Application No: EP/21/22/HH
Site Address: 35 The Ridings East Preston BN16 2TW
Description of works: Installation of front dormer.

Thank you for your internet representation made on 30th March 2022 which has been recorded as an objection with the comments as follows:

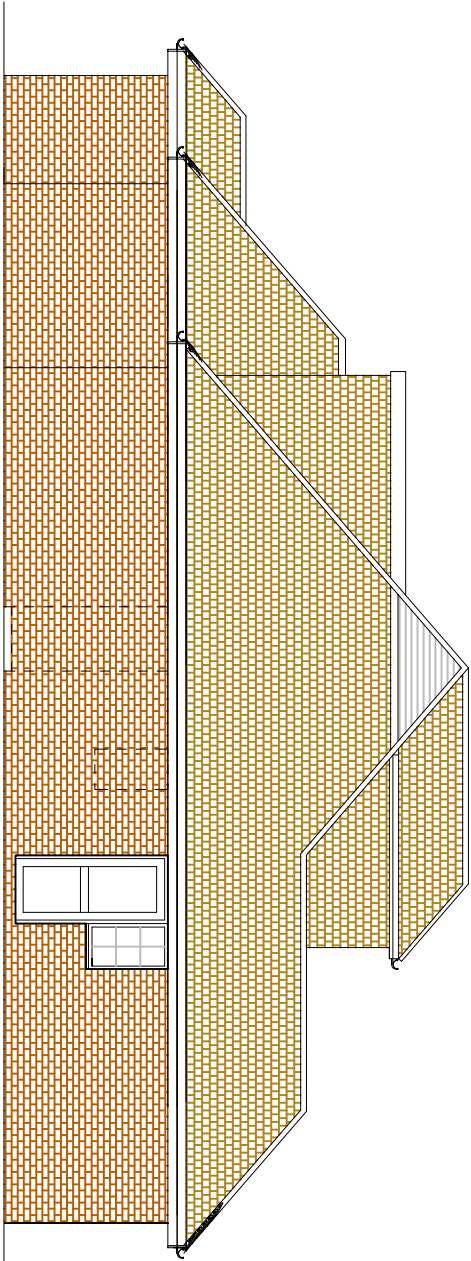
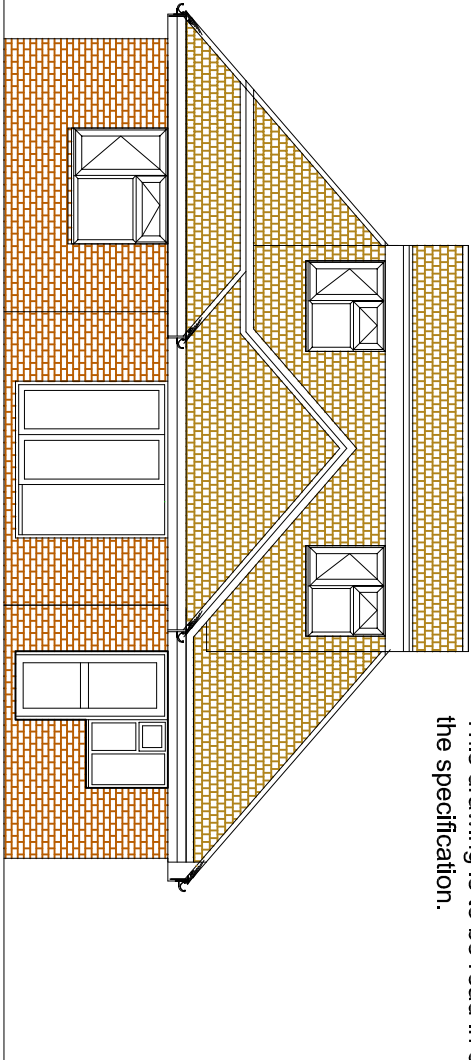
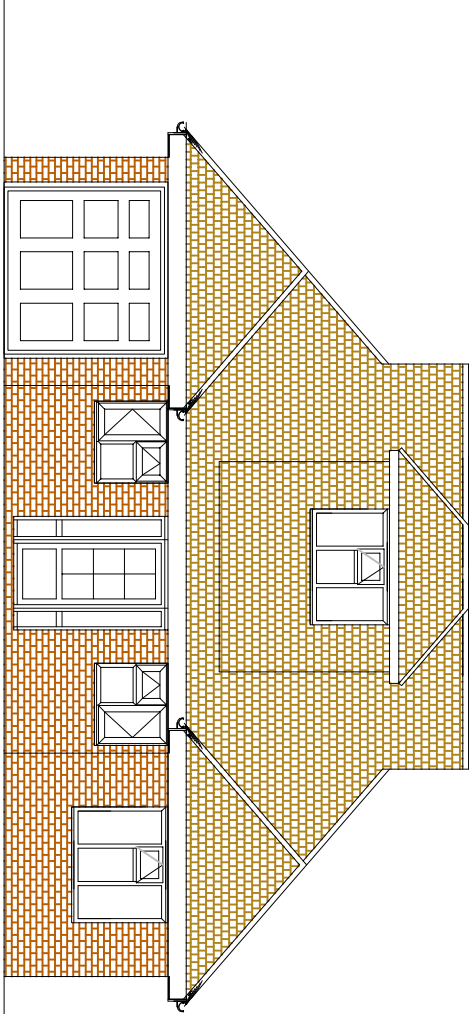
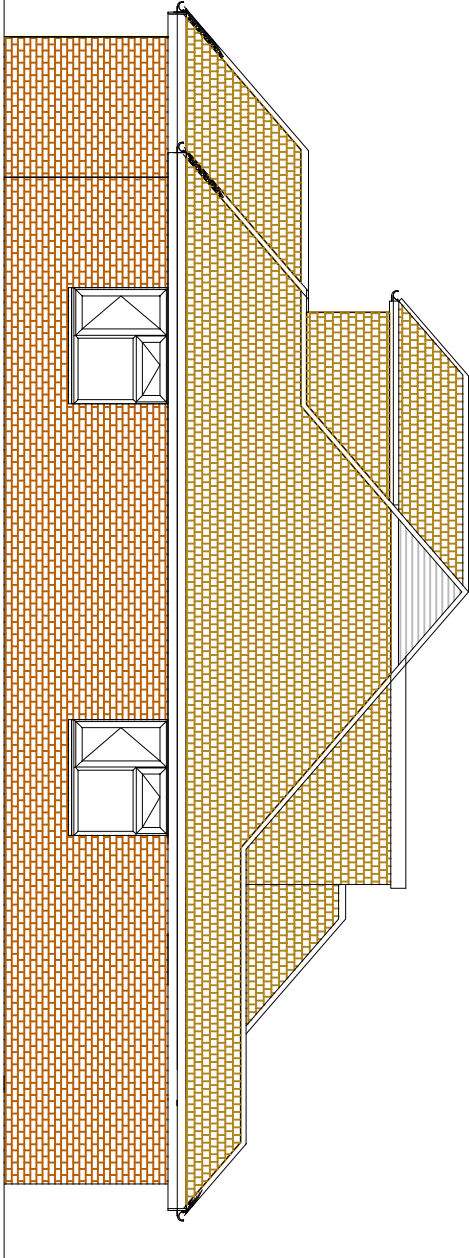
I write on behalf of the East Preston and Kingston Preservation Society to object to this application. The front dormer would be acceptable were it set below the roof ridge in a more subservient position. The lack of roof plan has made interpretation of the proposal difficult, and the elevation profiles look inconsistent, with both front and rear dormers seeming to be at the same height as the roof ridge at front and rear elevation drawings, though seem to be at different levels in the side elevation drawings. It appears that the rear dormer, not mentioned in the application, would protrude from both sides of the existing roof, giving an unbalanced, out of proportion and unacceptably rectangular appearance to the structure - out of keeping with neighbouring properties. Such a design could surely not be Permitted Development?
The Society therefore asks that this application be refused.
